**Consultation Response from KC,
Landscape - Emma Mills**
2020/90805 Land to North and South of, Crossley Lane, Dalton, Huddersfield, HD5 0QP
Reserved matters application pursuant to outline permission 2015/90430 for erection of residential development comprising (Use Class C3) and incorporating associated new access (to Crossley Lane and Cold Royd Lane), and associated works (123 dwellings)
Date Responded: 21.4.21 Responding Officer: EM Responding Ref: JJ36

Landscaping

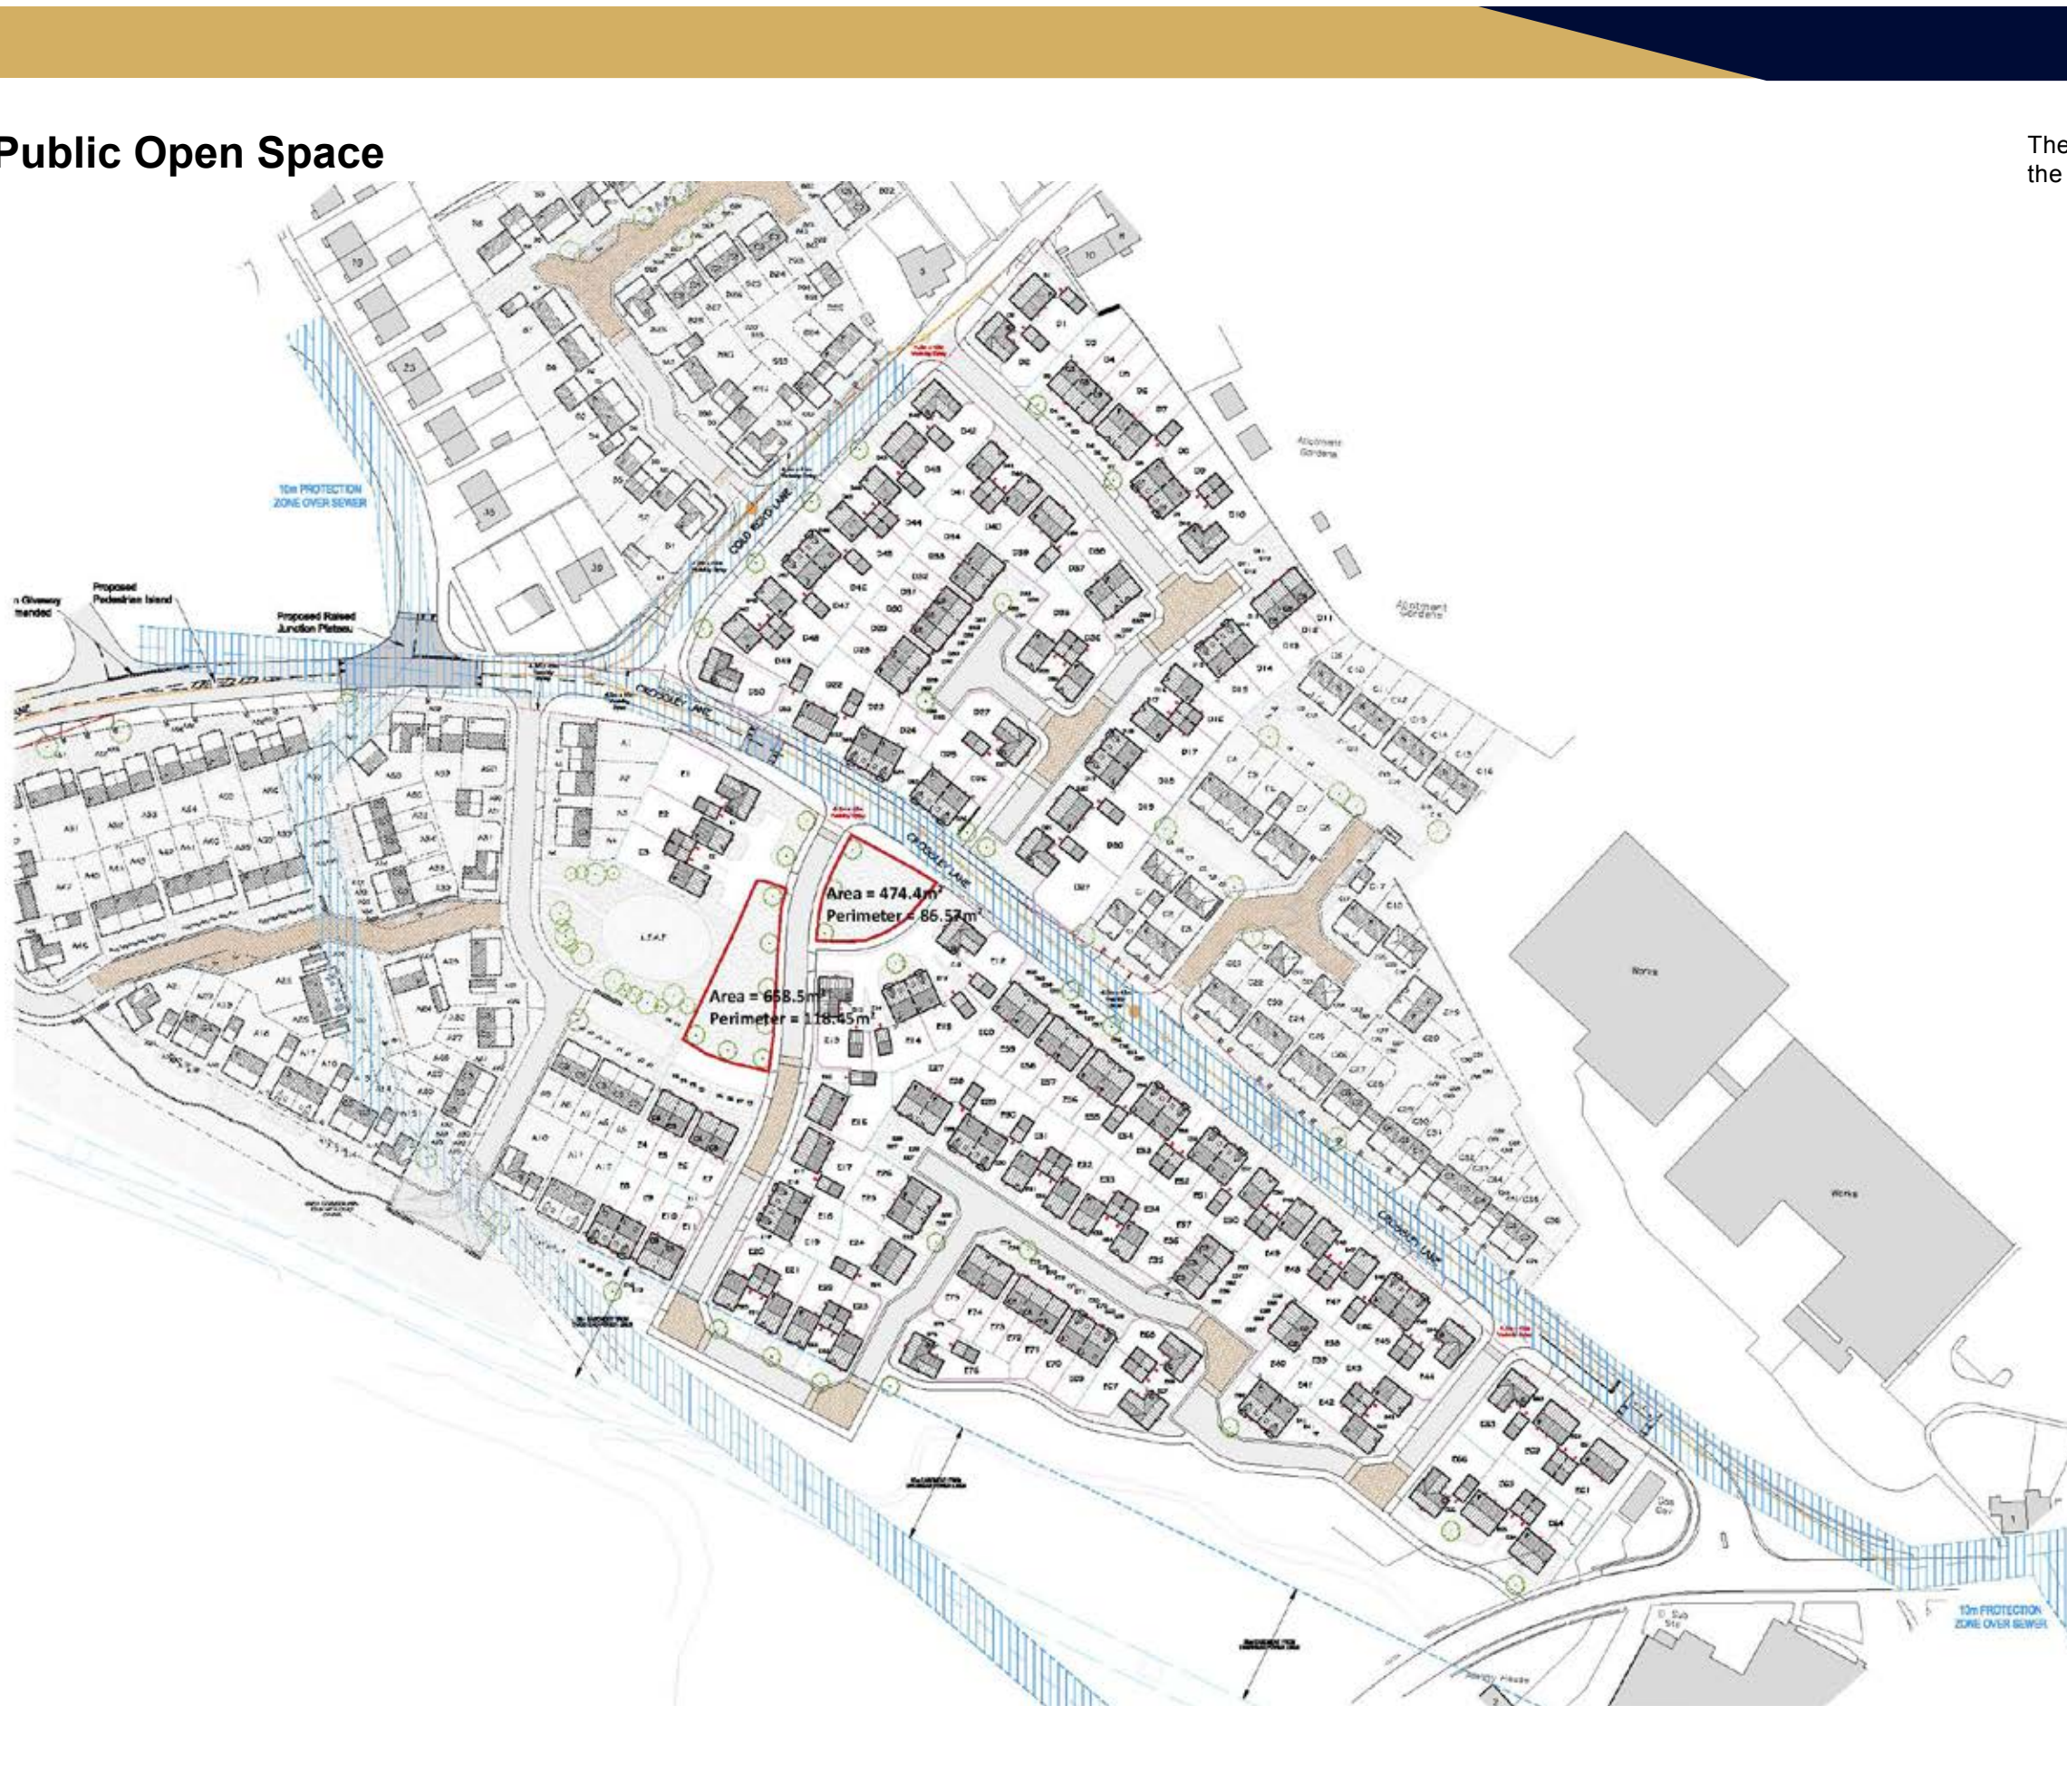
Given the following species are critical or urgent on the Plantlife list of invasive species we would recommend they are substituted for other species. plantlife.org.uk Here today here tomorrow

Other than the species replacements, the landscape scheme is acceptable.
